**WELWYN HATFIELD BOROUGH COUNCIL
ASSISTANT DIRECTOR (PLANNING)**

DELEGATED APPLICATION

Application No: 6/2022/2586/HOUSE
Location: 61 The Ridgeway Cuffley Potters Bar Hertfordshire EN6 4BD
Proposal: Erection of a single storey rear and front extension, increase in roof pitch, installation of two forward facing and one rear facing dormer, alterations to fenestration following demolition to existing rear and side extensions
Officer: Ms Kirsty Shirley

Recommendation: Granted

| 279 | 105 | D | |

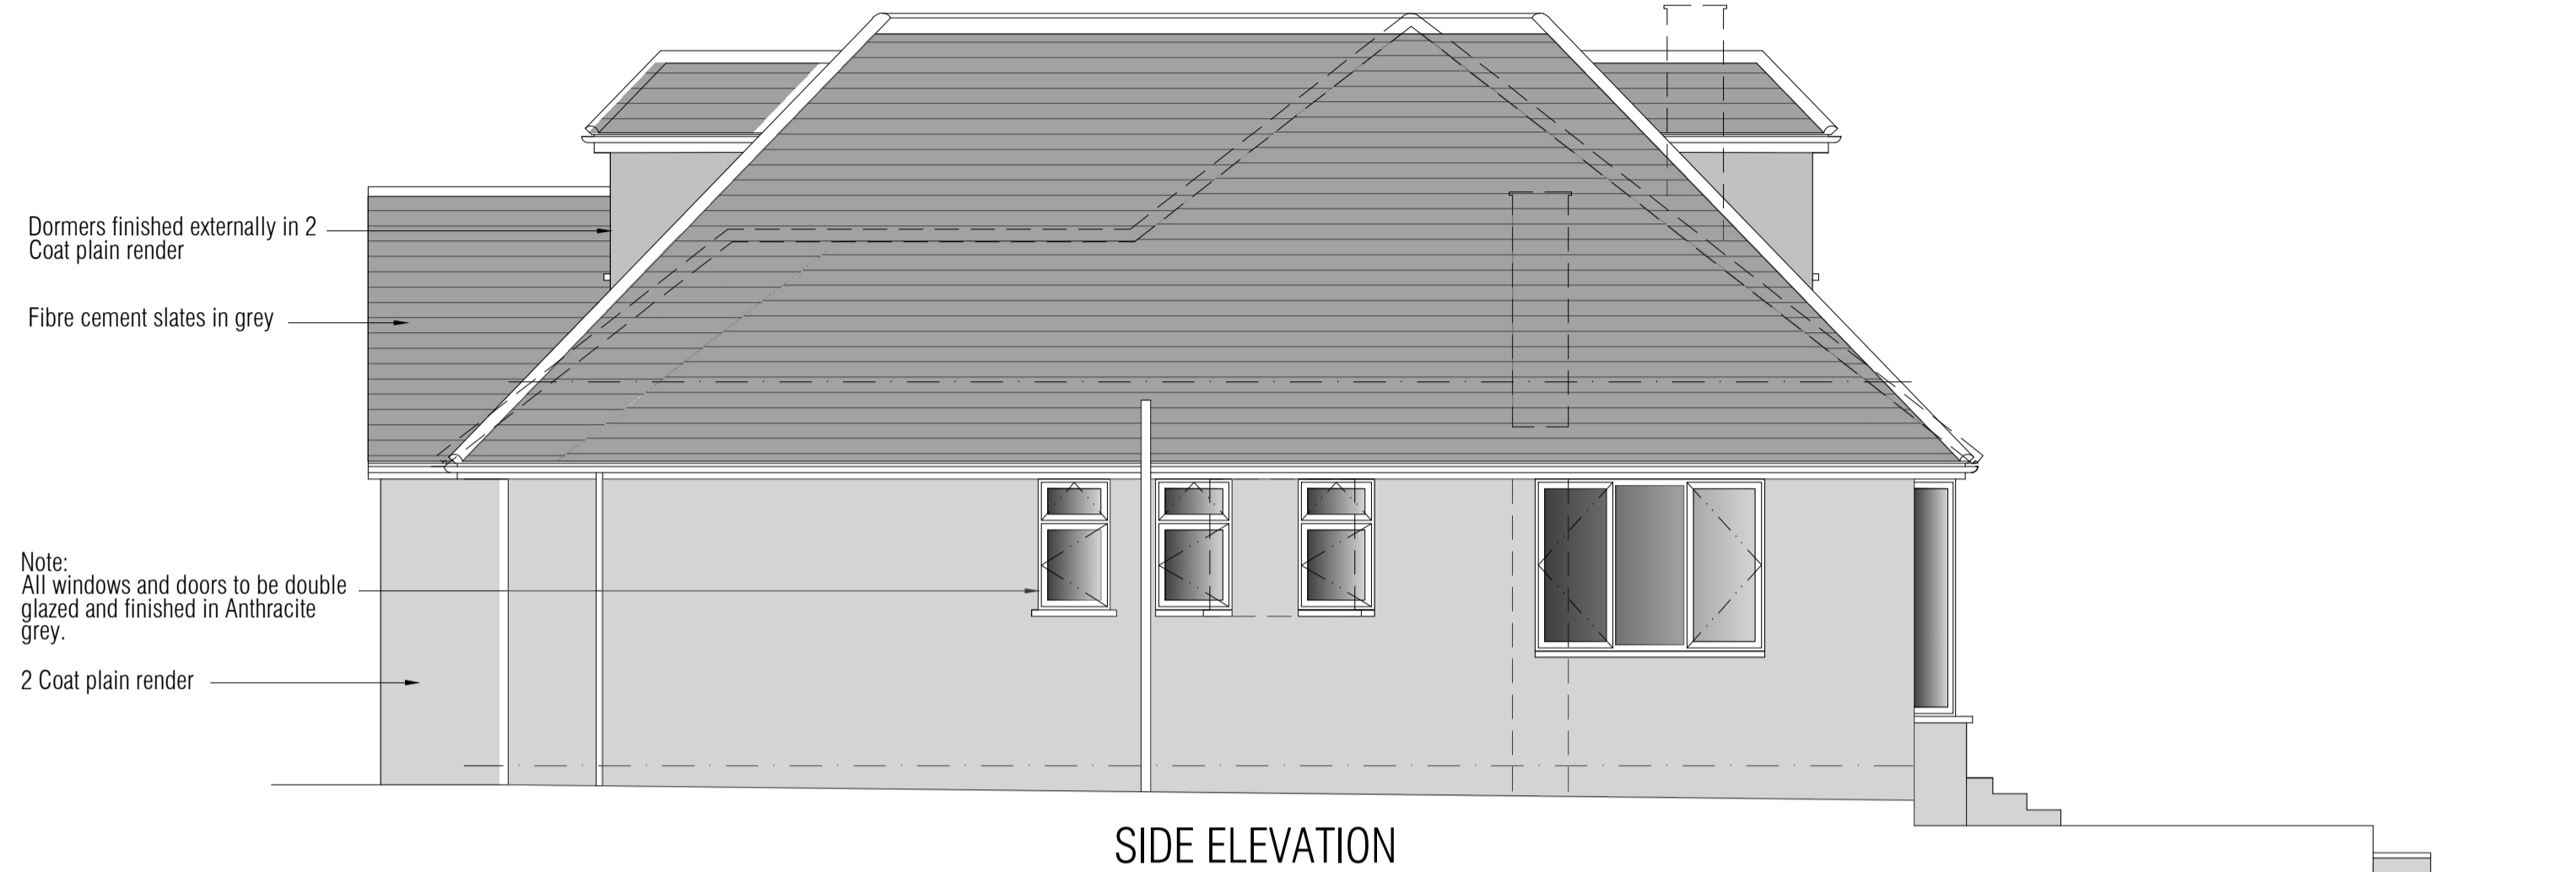
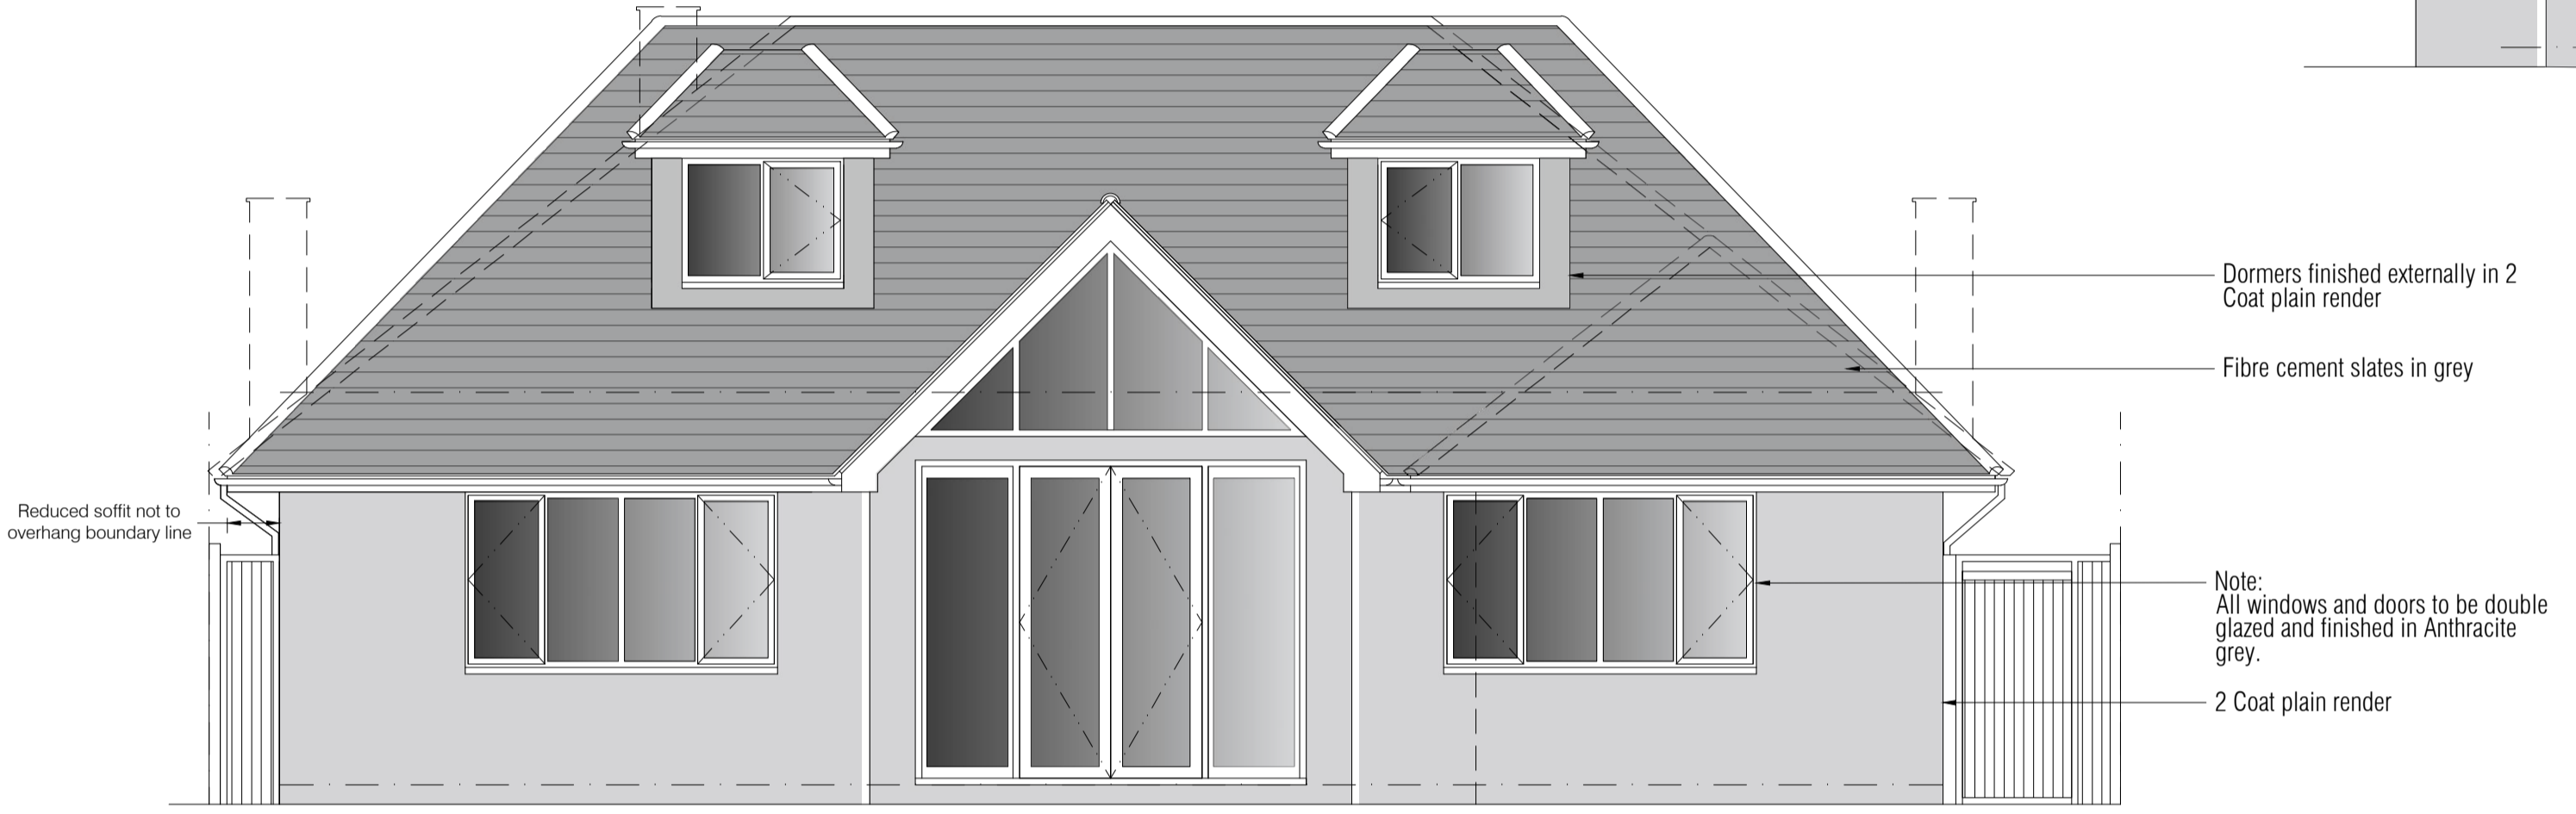
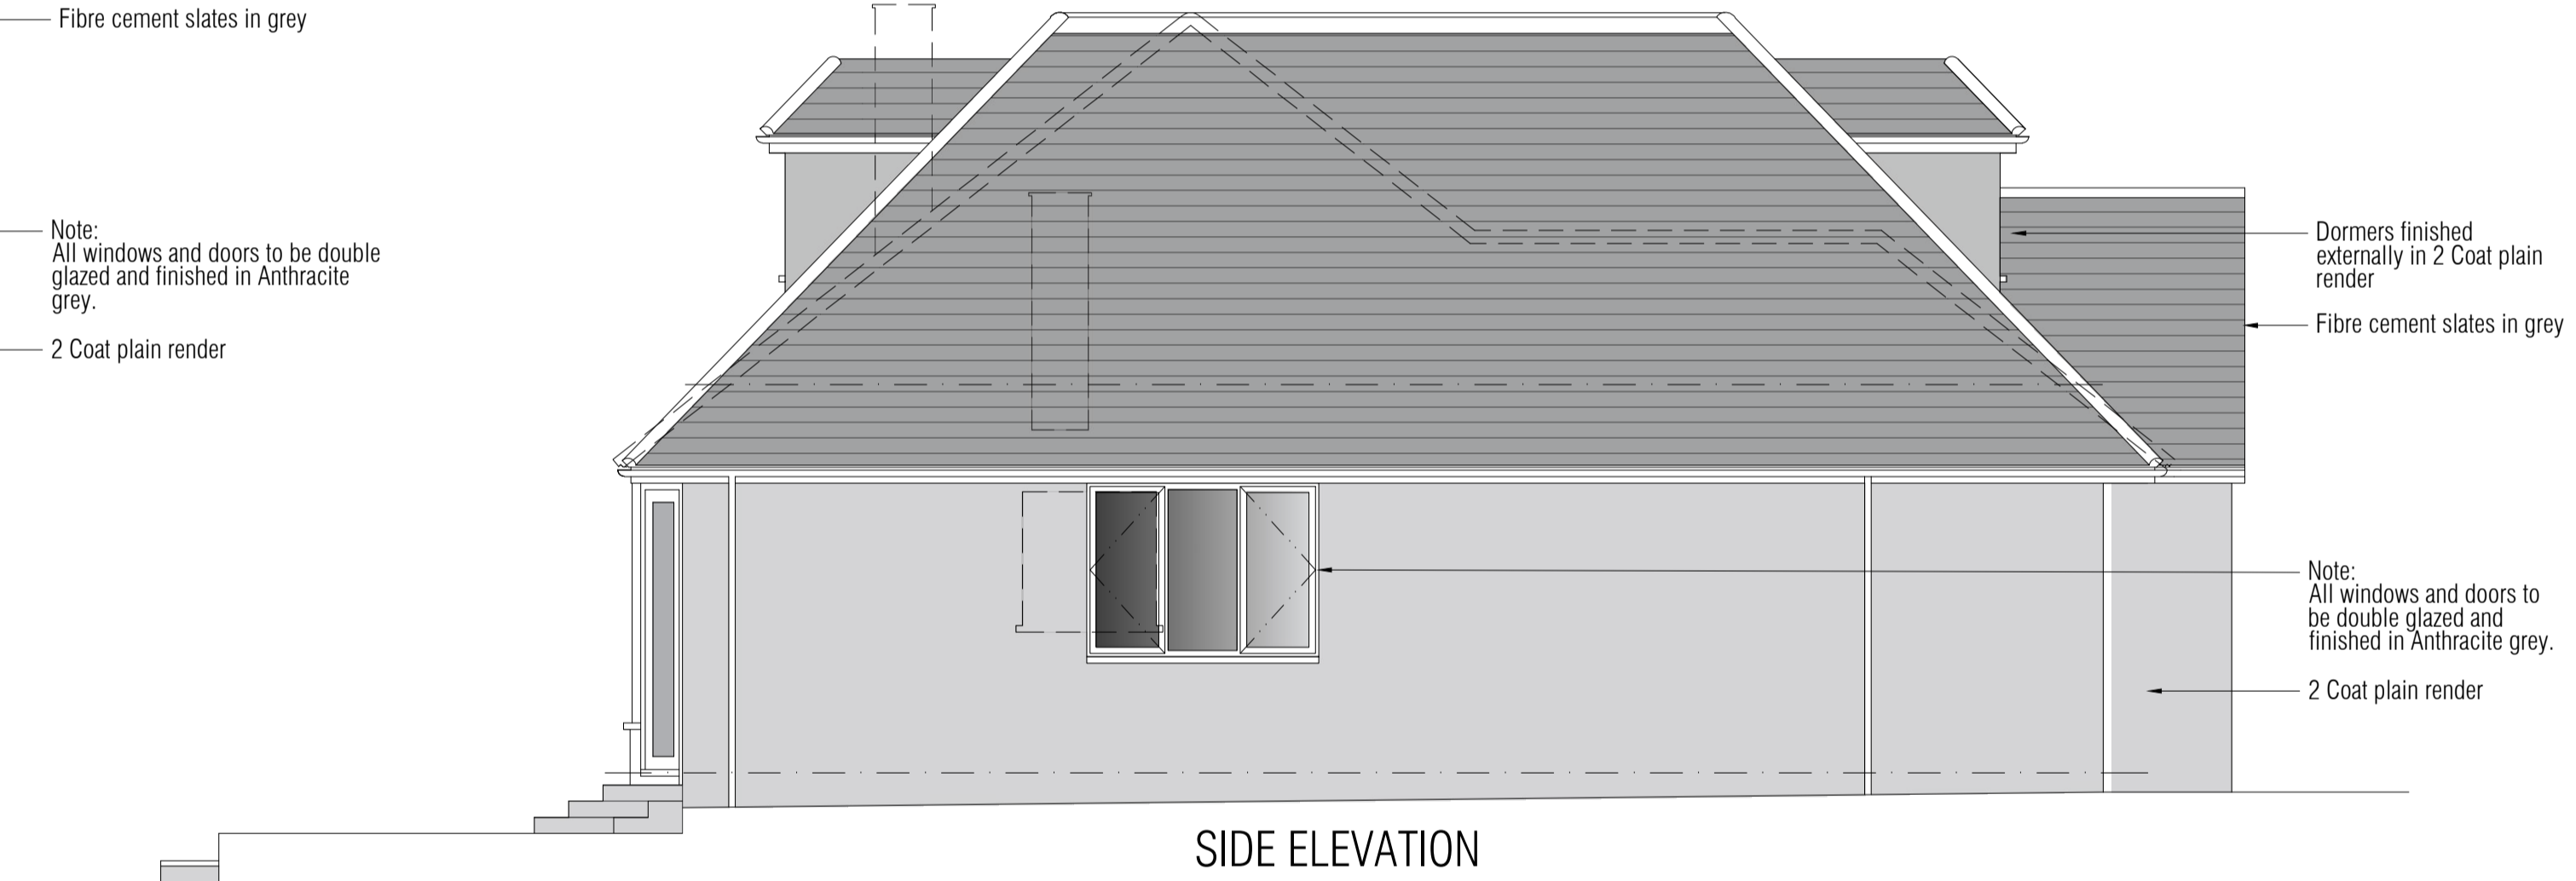
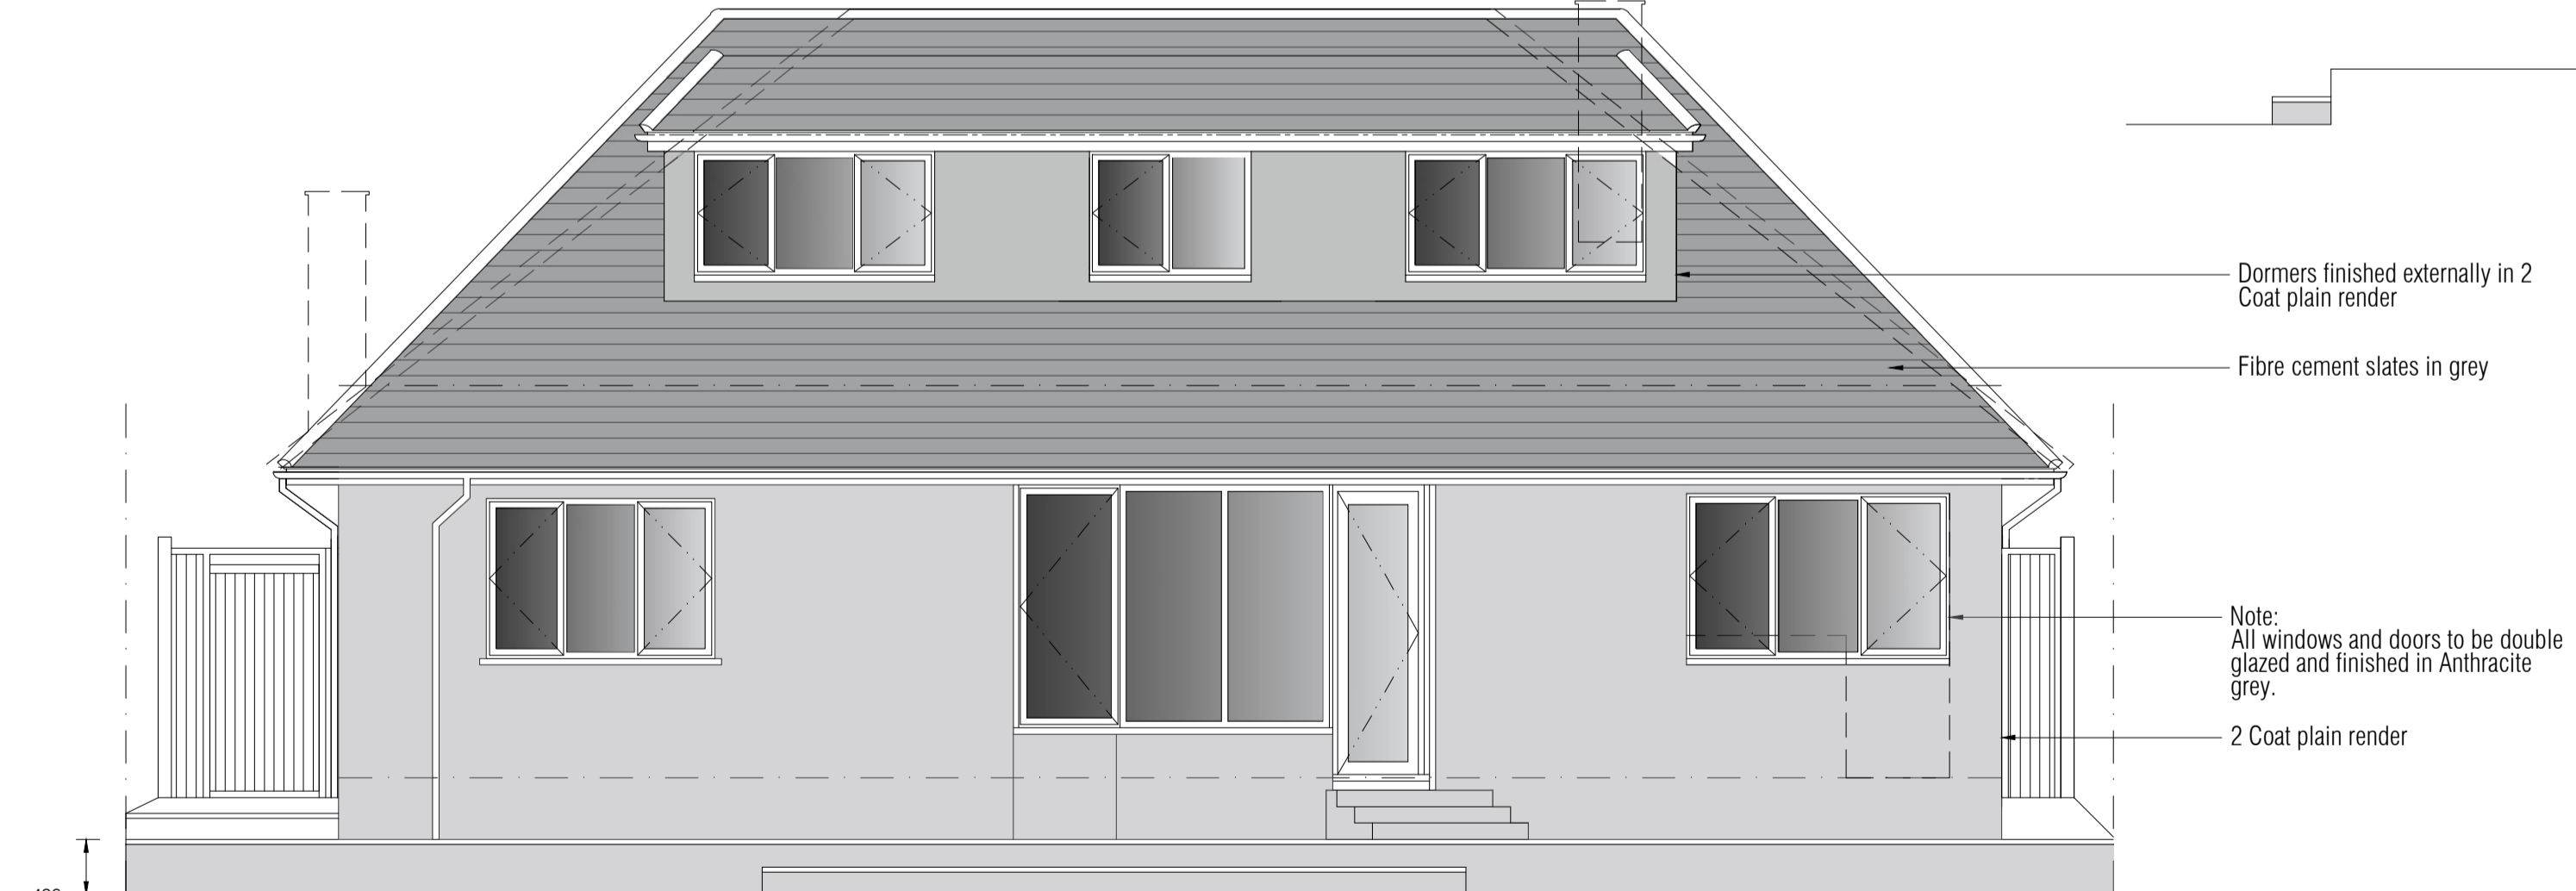
<p>Design (form, size, scale, siting) and Character (appearance within the streetscene)</p>	<p>This part of The Ridgeway includes mainly chalet-style and two-storey dwellings set back from the road. A key characteristic of many dwellings in this area are simple pitch roofs with gable features.</p> <p>The proposal would alter this roof form to a crown roof with two front facing dormers and a rear facing dormer. The increase in the roof size and scale as well as alteration to the roof form would not overwhelm the application dwelling and would not detract from the character of the area. Some crown roofs are not attractively designed which can significantly detract from the appearance of a dwelling and the overall character of the area. As such, in the event of an approval, a condition can be secured to ensure that the flat roof is be stepped down and concealed behind the surrounding pitched roof to ensure its impact in terms of visual amenity would be limited.</p> <p>The existing gable feature within the front elevation would be removed and the</p>

<p>front elevation would feature a gable feature above the entranceway, which would respect and relate to the character and appearance of the dwelling.</p> <p>The proposed dormers would be subservient within the respective roof slopes, positioned below the ridge of the dwelling with a suitable distance between the cheeks of the dormer and the flank elevations. The fenestration of the dormers would be in keeping with the fenestration proposed for the dwelling.</p> <p>The proposal would alter the fenestration of the dwelling. Casement windows feature throughout the elevations dwelling, most notably as bay windows within the front elevation of the dwelling. Elsewhere, the dwelling features large picture windows and sliding doors. While there is variety in the fenestration featured within the area, casement windows are predominant. Casement windows that a more consistent in size and style would be inserted into the elevations, which would respect and relate to the proportions of the dwelling.</p> <p>The submitted plans have annotations describing different materials to the materials currently featured on the application dwelling. To ensure that the proposed materials would not detract from the appearance of the dwelling or character of the area, submission of material samples can be secured by condition.</p>
